The Issues Associated with the Design of the Proposed Relocation of the Berry Equestrian Centre

This submission concerns the impact of the proposed Foxground and Berry Bypass on the Berry Equestrian Centre which is located in North Street Berry.

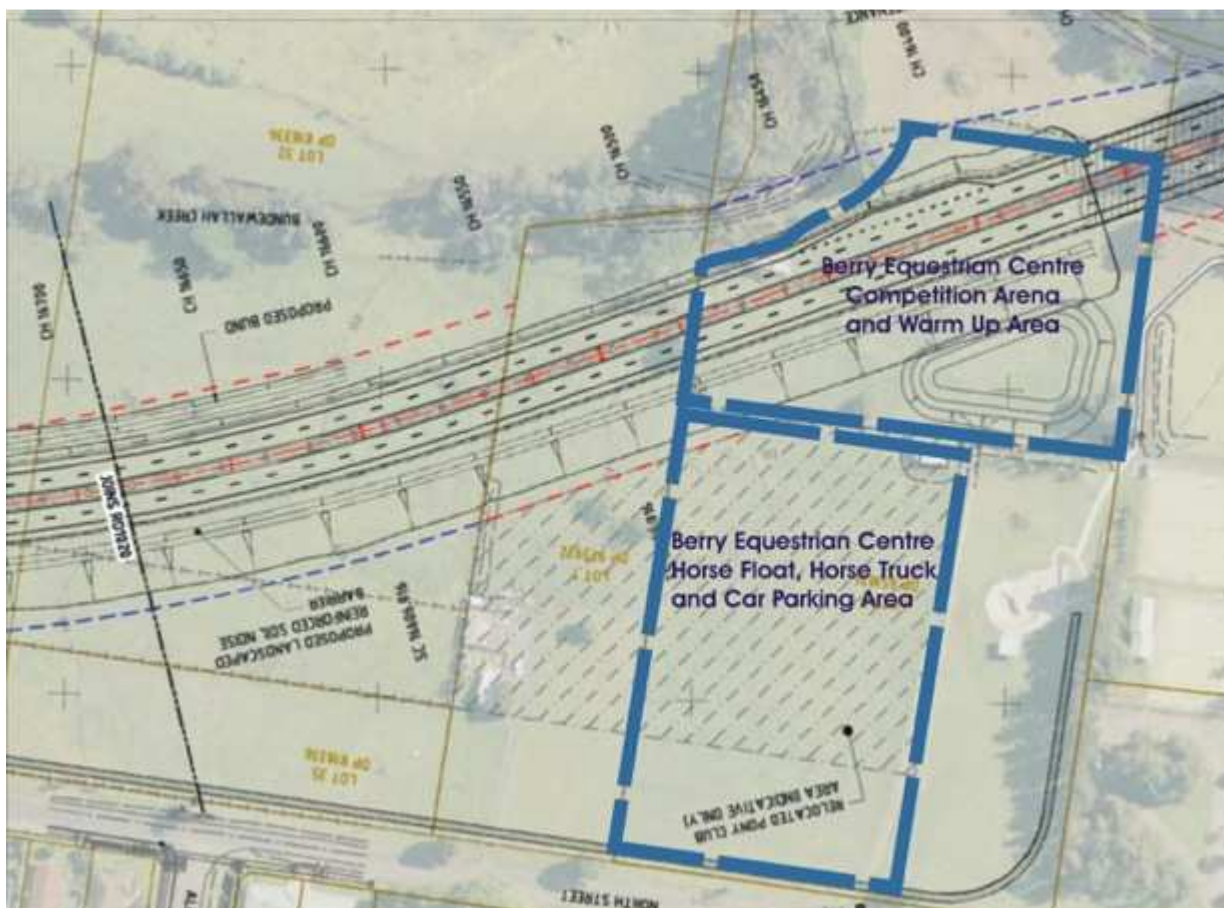
The design and loss of land of the proposed relocation of the Berry Equestrian Centre will have a significant impact on the ability to conduct events. It will impact riders, participants and spectators in the following ways.

1. The competition grounds are required to be rectangular /square in shape of a minimum size of 140 metres x 140 metres with a level, well drained, good riding surface in order to cater for at least 4 dressage arenas or 2 showjumping arenas.
2. The parking area is required to be of a minimum area equivalent to 90 metres x 160 metres and allow for easy entry, maneuverability, parking and exit of horse floats and trucks. Each parking space is equivalent to an absolute minimum of 4

normal vehicle spaces due to the need for unloading/loading and tie up areas for horses.

3. There is concern for the safety of horses, riders and the general public due to the near location of the proposed riding area to the 4 lane expressway, the skateway, the public cycleway/walkway and North Street. There will be anticipated significantly increased noise and visibility of cars and trucks travelling at 100km/hour on the expressway with horses competing nearby, often with young, very inexperienced riders.

4. Access to the grounds is likely to be across a public shared cycleway/pathway. The safety of children on skateboards, bicycles etc are at risk as horse trucks and floats cross the pathway. Horse floats and trucks also require an indented driveway of at least 15 metres to allow vehicles to park off the roadway whilst gates to the grounds are opened.
